Application No : 2011/0666

Description : Extension to Clubhouse

Location : Houghton Main Recreation Ground

Amendments : as discussed please find enclosed amended plans which comprise :

DRAWING OF  
**BLOCK PLANS**

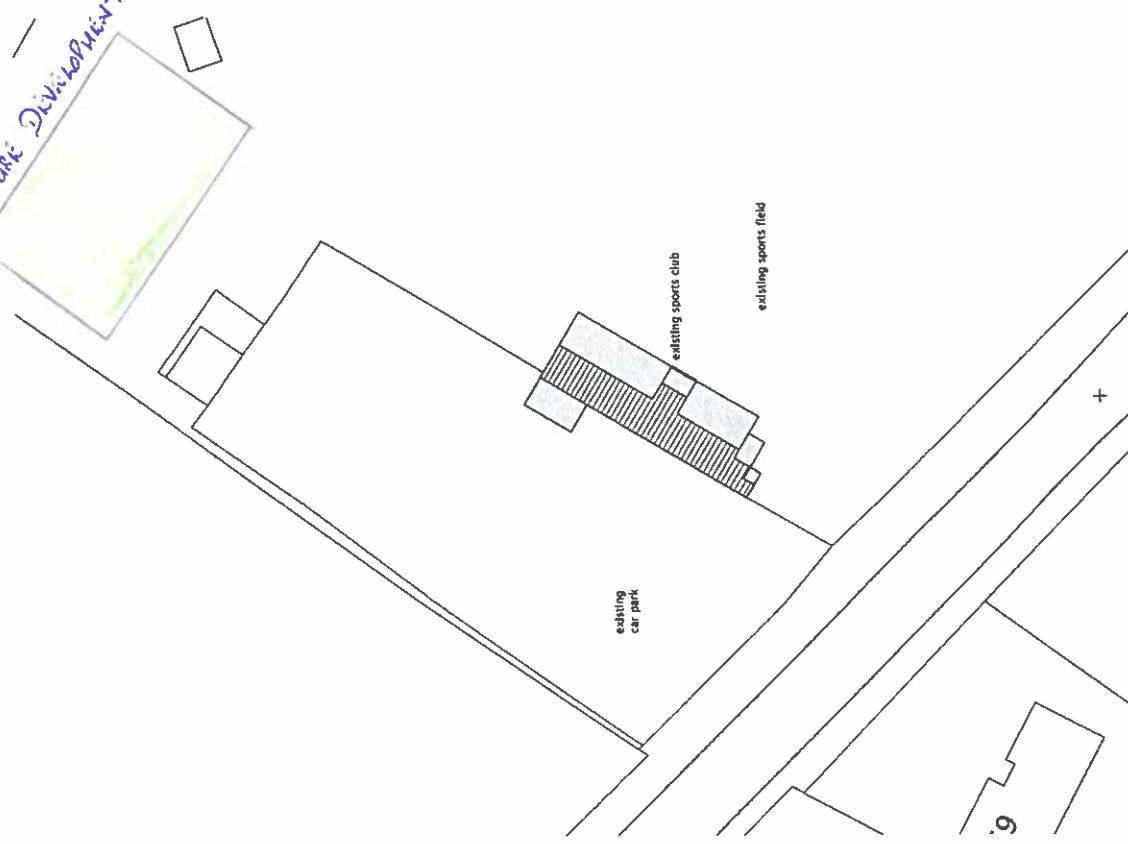
- facilitate training and youth matches, without overplaying the existing pitch.
- facilitate batting cages for the cricket section, and
- include a bowling green for the older members of the community.
(please find enclosed computer sketches of proposed layout).

DRAWING OF  
PROPOSED ELEVATIONS

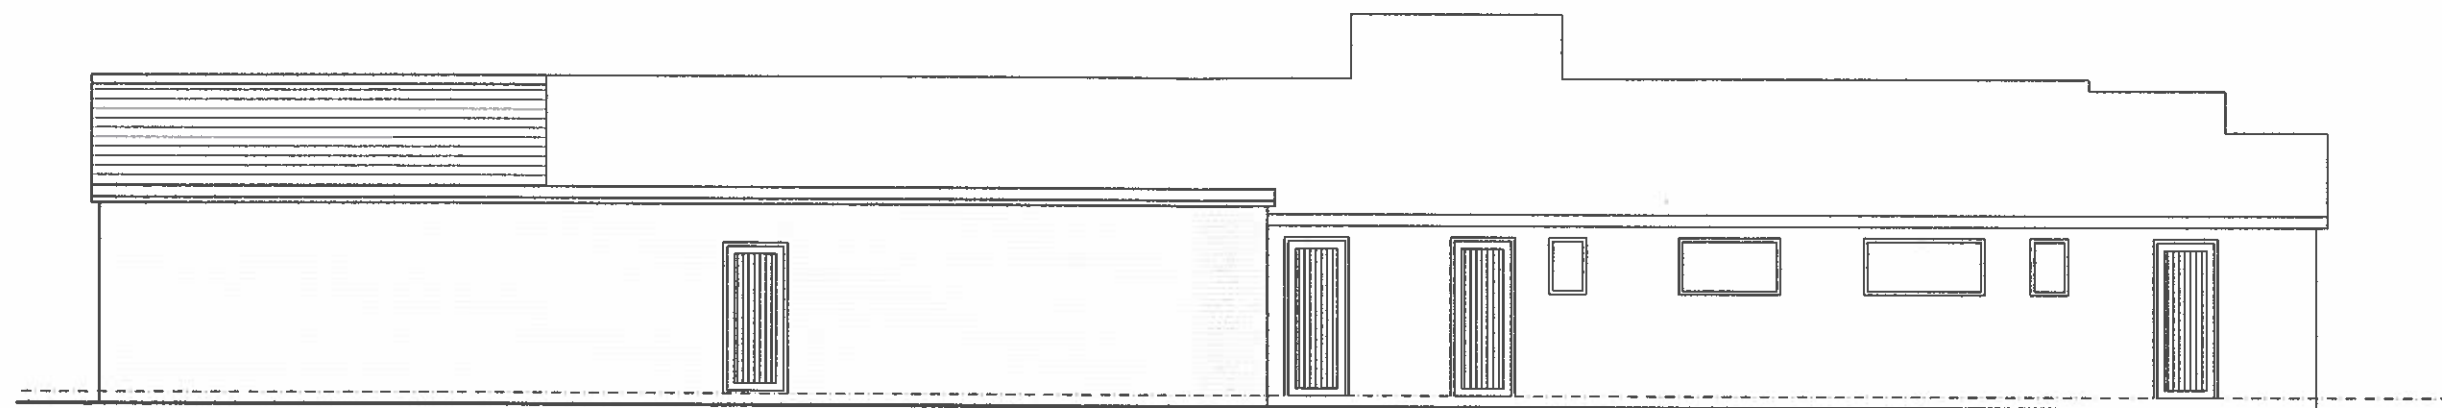
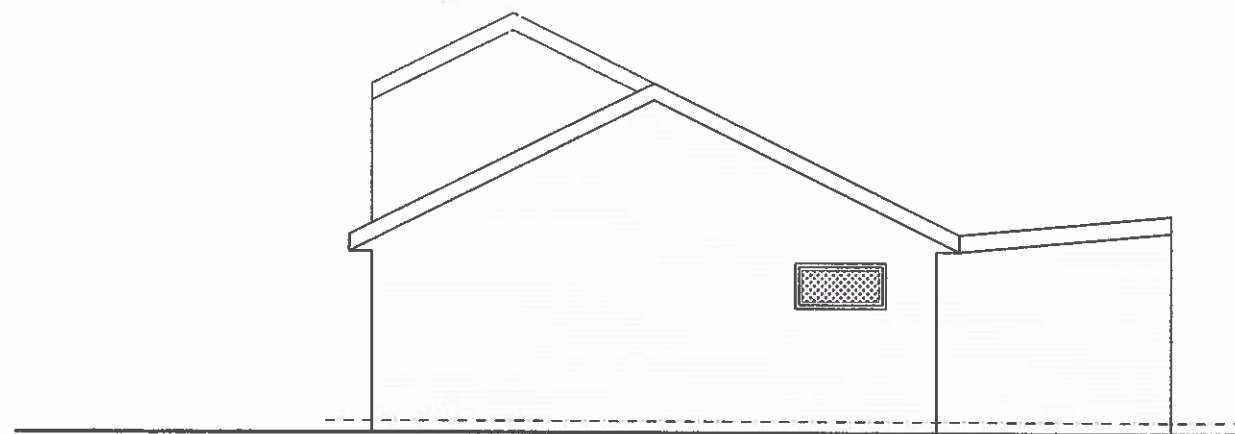
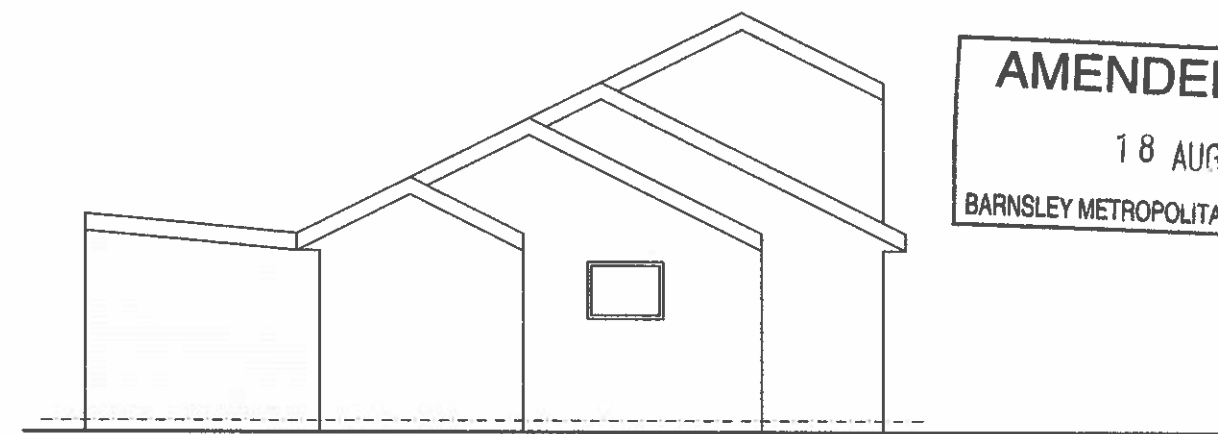
- removal of the extension which projected forward of the principal elevation, and therefore eliminating any harmful visual effect upon the amenities of the Green Belt.
- the proposed extension to the western elevation of the building would comprise kitchen and toilet facilities.
- the proposed extension to the sports pavilion would ensure that everything would be maintained in it's current elongated state, with the side of the building facing the highway, as you suggested, without encroaching upon the openness of the area.
- a more accurate description of the internal areas, my apologies for the misleading information previously provided.
